**Consultation Response from KC,
Highways Development Management**

2024/90792 Former Whiteley Engineering Works Site, St. Peg Lane, Cleckheaton, BD19 3SH

Use of land for storage and fit-out of acoustic containers with generator units and associated electrical equipment, with reinstatement of former access to St. Peg Lane, erection of security fence and siting of security and welfare cabins

Date Responded: 23-10-2024.

Drawing Title:
VISIBILITY SPLAYS

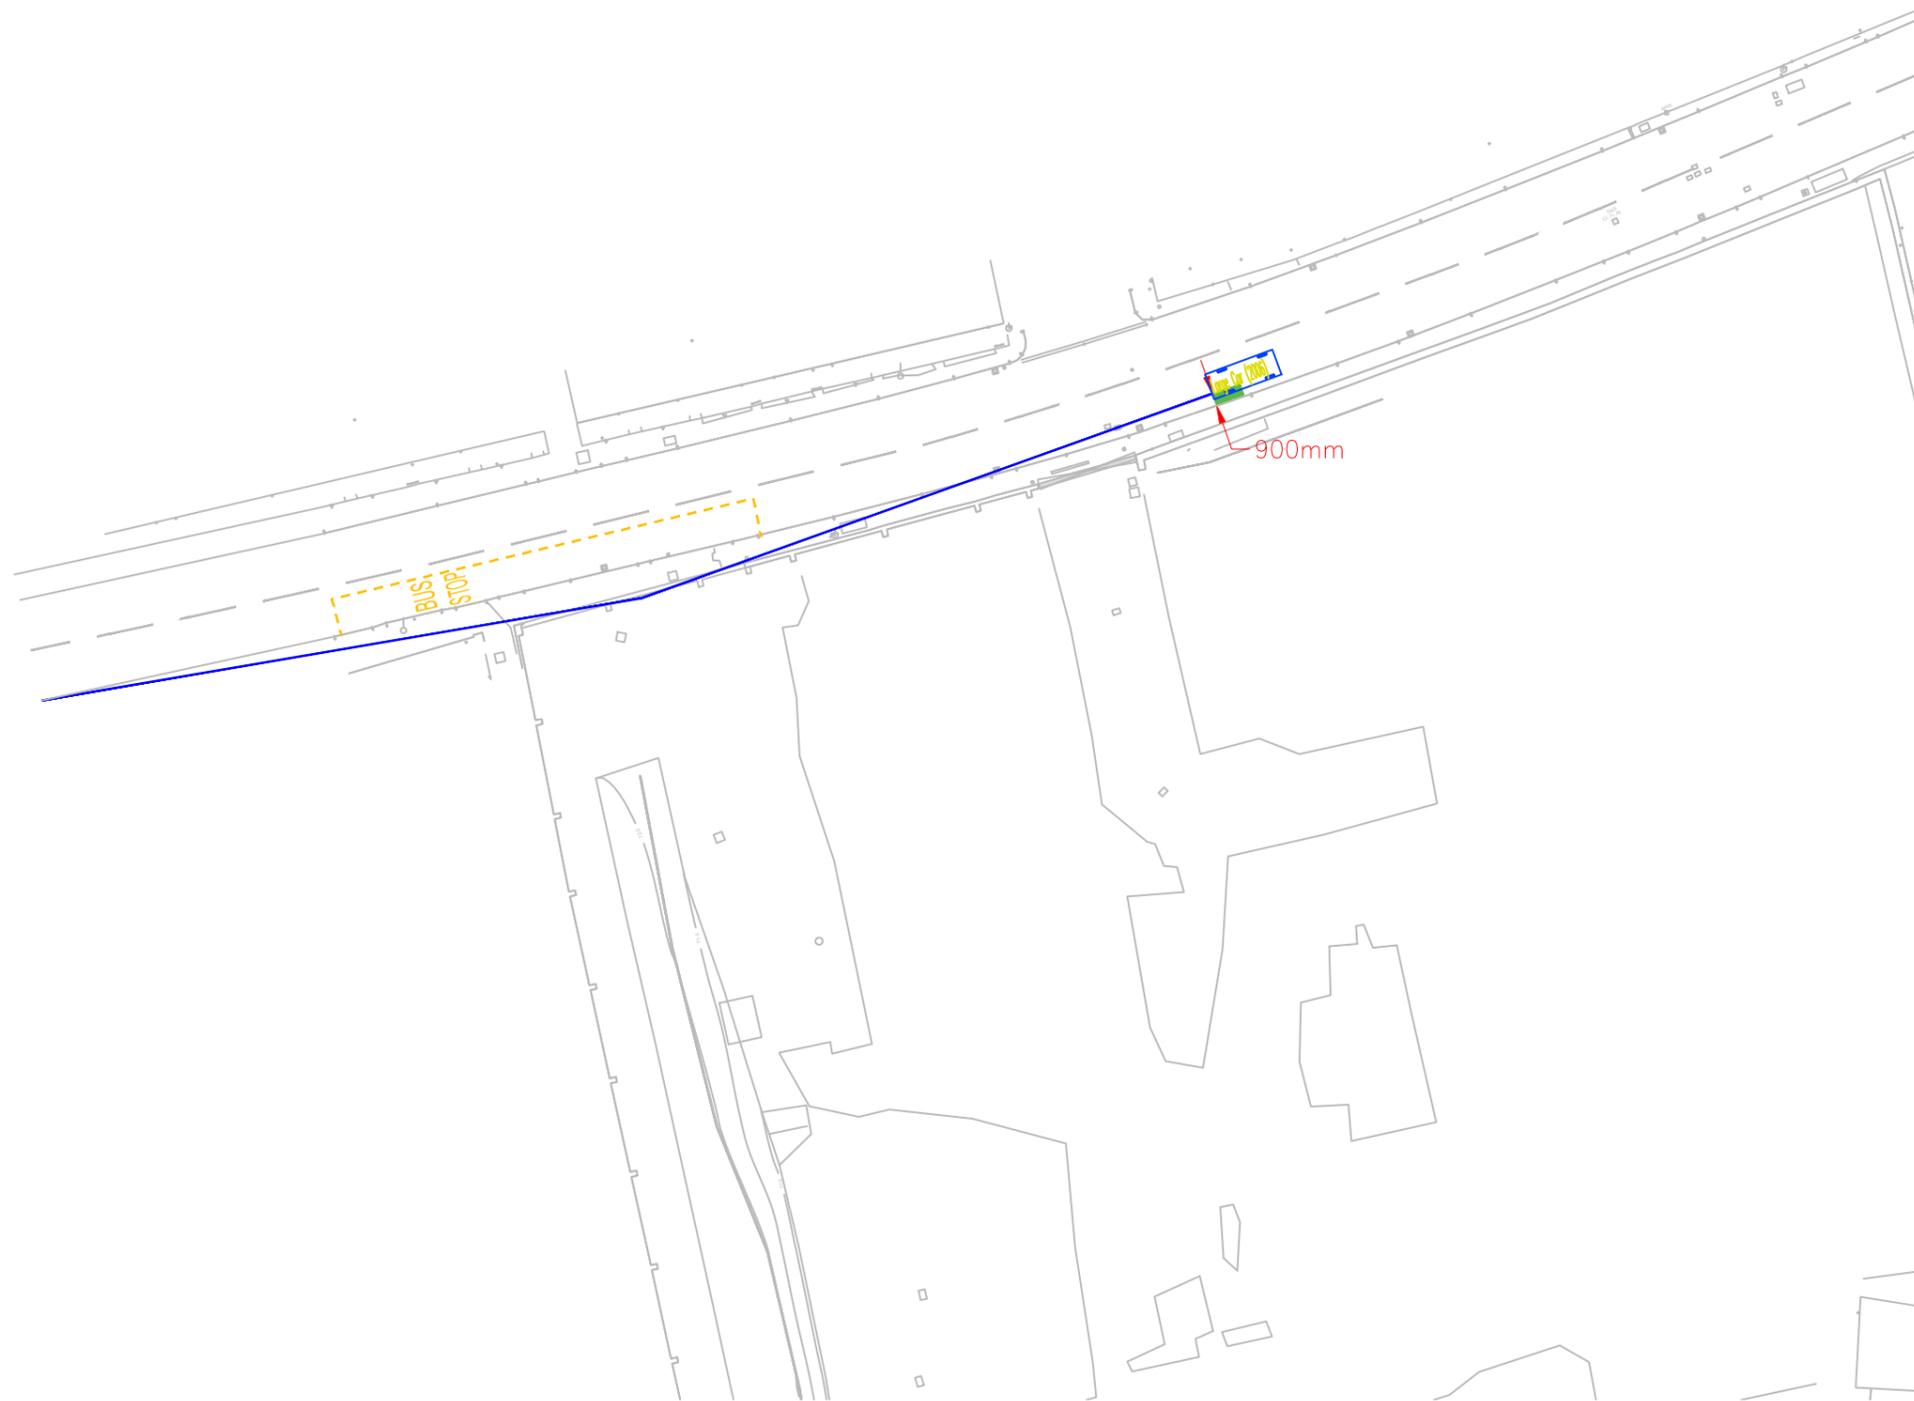
- 1, The footway to the site frontage is narrow at approximately 1.2m and should be shown to be widened to 2.0m to the full site frontage to improve pedestrian facilities in the area including to the adjacent school.
- 2, No details of the proposed sight lines from the proposed access onto St Pegs Lane are provided. 2.4 x 43 m sight lines need to be shown.
- 3, Can the applicants explain how the proposed gates are to operate HDM would not want to see vehicles waiting on St Pegs Lane.
- 4, Can the applicants be asked to provide details of all anticipated vehicles movements into and out of the site.
- 5, Details of the proposed staff parking areas should be provided.
- 6, Consideration should be given to the re-siting of the existing bus stop to the frontage of the site.

- 2, Drawing ref. 23005. SK.01 shows visibility splays of 2.4m x 43m are achievable with the proposed access arrangement.
- 3, The site will have a 24/7 security personnel presence in control of the site access gates. All HGV movements into and out of the site are planned and coordinated by Wakefield Acoustics. The outer gates shall therefore be opened ahead of any vehicle arrival at the site. If further control is necessary, then we suggest that a condition may be used to require approval and conformity to a 'service and delivery management plan' or similar.

Given that acceptable sight lines are shown at the site access onto St Peps Lane, staff parking is now shown to be provided, the very low anticipated vehicle movement and that the applicants have suggested a service and delivery management plan HDM have no further objection to these proposals.
